14/01601/LB

Chancel Cottage, Fir Lane, Steeple Aston, Bicester, OX25 4SF

**Application Description:** Internal alterations, external alterations (including insertion of six rooflights), demolition of attached outbuildings and erection of single storey extension

### Report Type: Delegated Decision

Fig.29 - Proposed First Floor Plan

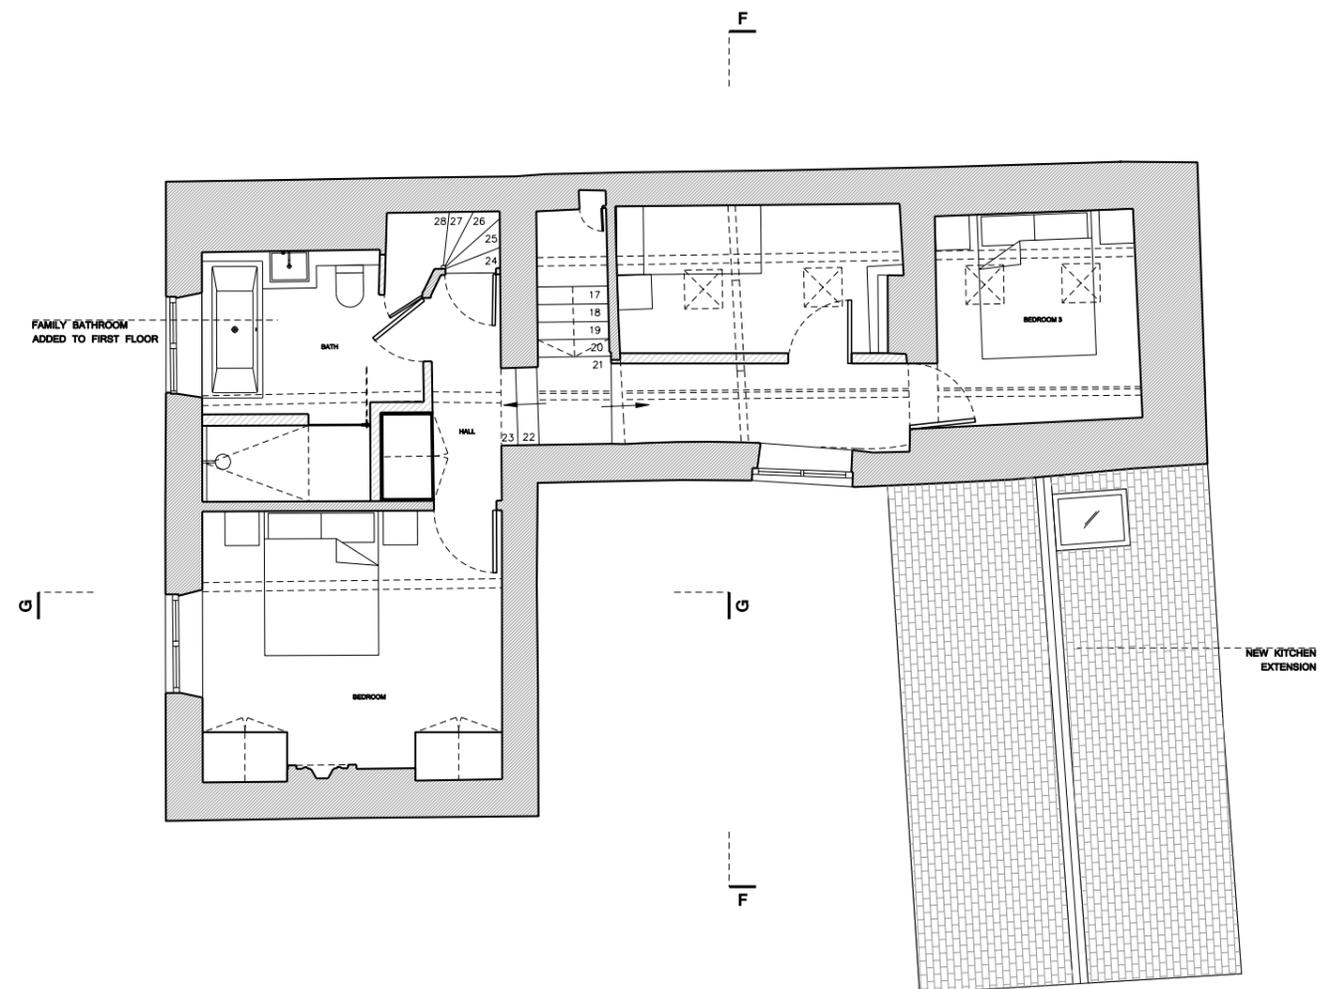
- 5.14 However, the proposal to form an additional doorway at first floor level is considered to have a more significant impact. The doorway is between the original stable range and the later 19<sup>th</sup> century addition, which was constructed as a physically separate structure. The ground floor area of the building has been brought into domestic usage, but the first floor area remains unconverted and unused. There is evidence of a former opening at first floor level which has since been blocked up. It is considered that there would be some harm to the significance of the site if this element of the building were to be converted, although this would need to be weighed against the public benefit of bringing this section of the building into use with the associated benefits of better maintenance.

- 5.16 Rooflights are not a characteristic element of simple, vernacular cottages such as this one and would have a detrimental impact on the character and appearance of the heritage asset. Although proposed to be set flush within the roof slope, the cumulative impact of the number of rooflights proposed is considered to cause substantial harm to the character and appearance of the listed building. The proposed use of the roof space for a further bedroom is considered acceptable in principle.

Chancel Cottage - Proposed West Elevation

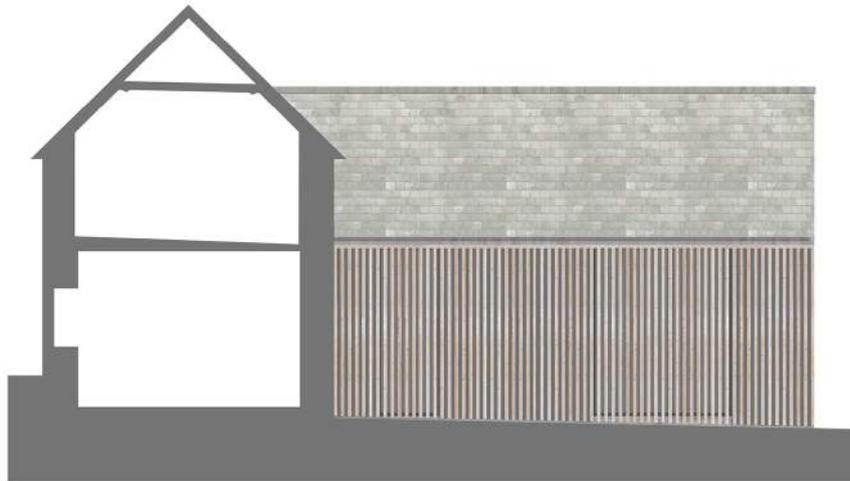
- 3.2 **Conservation Officer** – Objects, principally on the grounds that the form, scale and massing of the proposed extension causes harm to the significance / special interest of the listed building. Also concerned with the use of timber boarding and any dormers proposed (Detailed comments retained on file)

- 5.8 Neither is the inclusion on drawing "059\_1\_314 P12" of new screen planting to the front considered to mitigate the identified harm. The height and thickness of this planting would vary seasonally and over time and, in any case, would take several years to grow to a height where would screen the extension to any significant extent. It is highly unlikely that the screen planting would ever fully obscure views of the extension (Section AA on drawing "059\_1\_301 PL02" gives a fair indication). In addition, the fact that screen planting is proposed as mitigation draws attention to the significant and demonstrable harm that would be caused.
